Re: State Significant Infrastructure – SSI-74258485 – Greater Parramatta, Olympic Peninsula Water Cycle – Advice on EIS

Thank you for your referral of this State Significant Infrastructure project dated 11 February to DPIRD Fisheries, a division of NSW Department of Primary Industries.

Figure 3-8 Indicative layout of the proposed river release structure

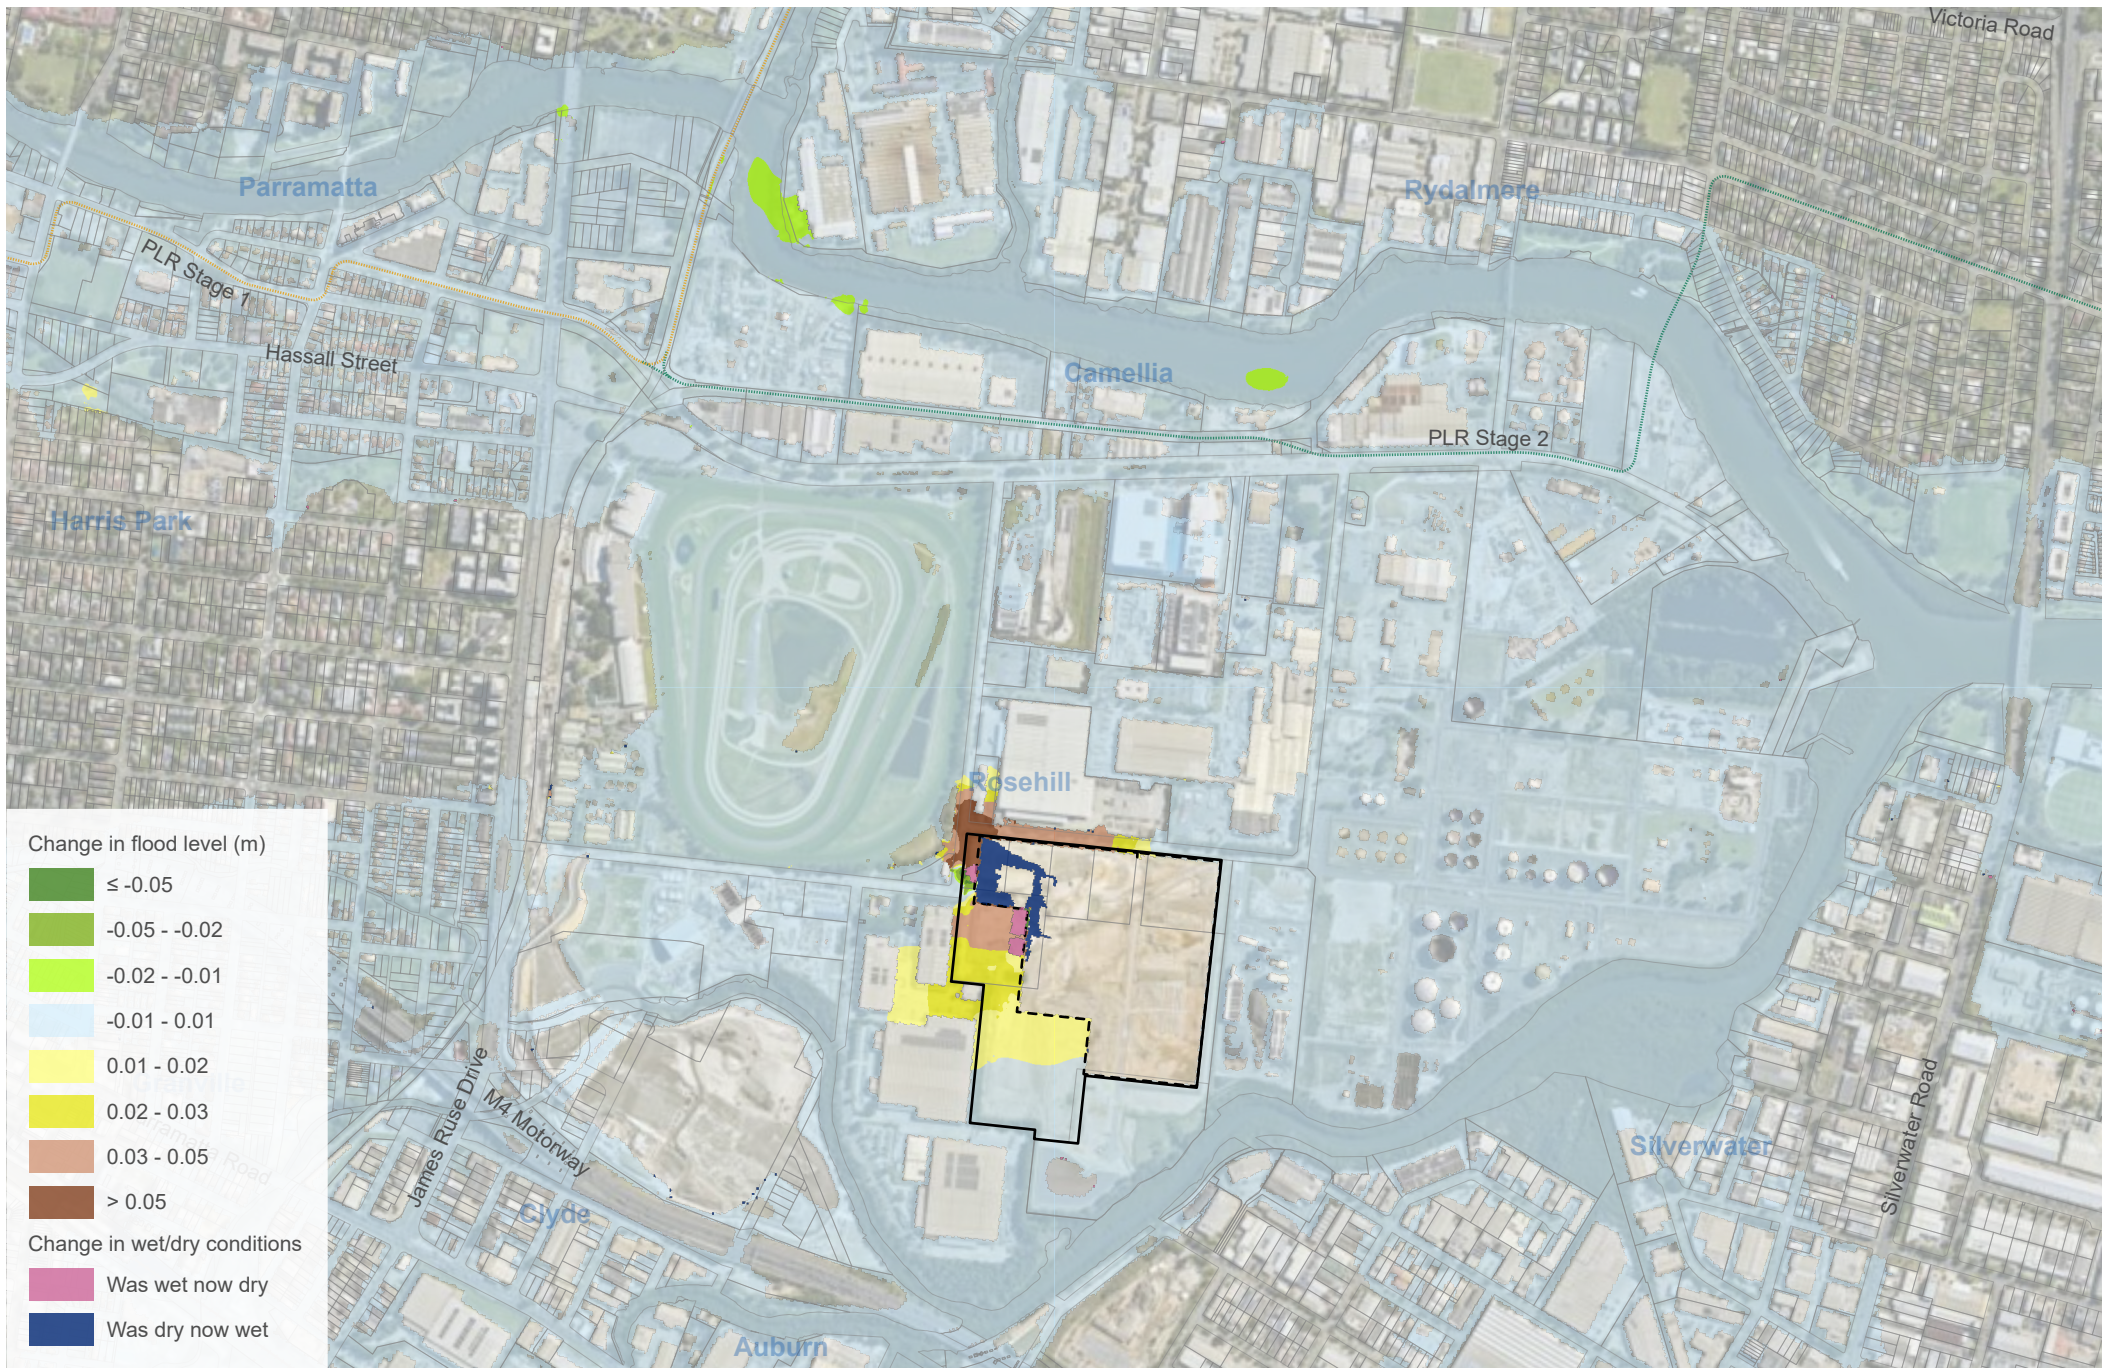
DPIRD Fisheries considers that the EIS has adequately identified, assessed and mitigated the potential impacts to KFH, including commitments to ongoing monitoring of long-term water quality changes and potential effects on adjacent SEPP Coastal Wetlands. However, the footprint of the discharge point (concrete mattress) within the Parramatta River is likely to be substantial and will overlay Type 3, Class 1 KFH as defined in the *Policy and Guidelines for Fish Habitat Conservation and Management* (2013). In our view, this represents an unavoidable loss of KFH.

The EIS concludes that offsets are not required on the basis that the affected habitat is of low ecological value and that the proposed infrastructure will itself provide habitat-forming structure. While these considerations may have merit, they do not remove the requirement to offset the loss of KFH.

DPIRD Fisheries supports development of a Marine Biodiversity Offset Strategy (MBOS), noting that habitat creation is preferable to repair. We acknowledge the proposal to rehabilitate the existing seawall and install Living Seawall boulders along disturbed and adjacent sections, and recommend investigating opportunities to extend these measures to nearby seawalls outside the immediate disturbance footprint.

1. Impacts to Key Fish Habitat must be avoided wherever possible. Where impacts are unavoidable, offsets must be applied at a 2:1 ratio.
2. A Key Fish Habitat Offset Strategy (MBOS) must be prepared in consultation with DPIRD Fisheries.
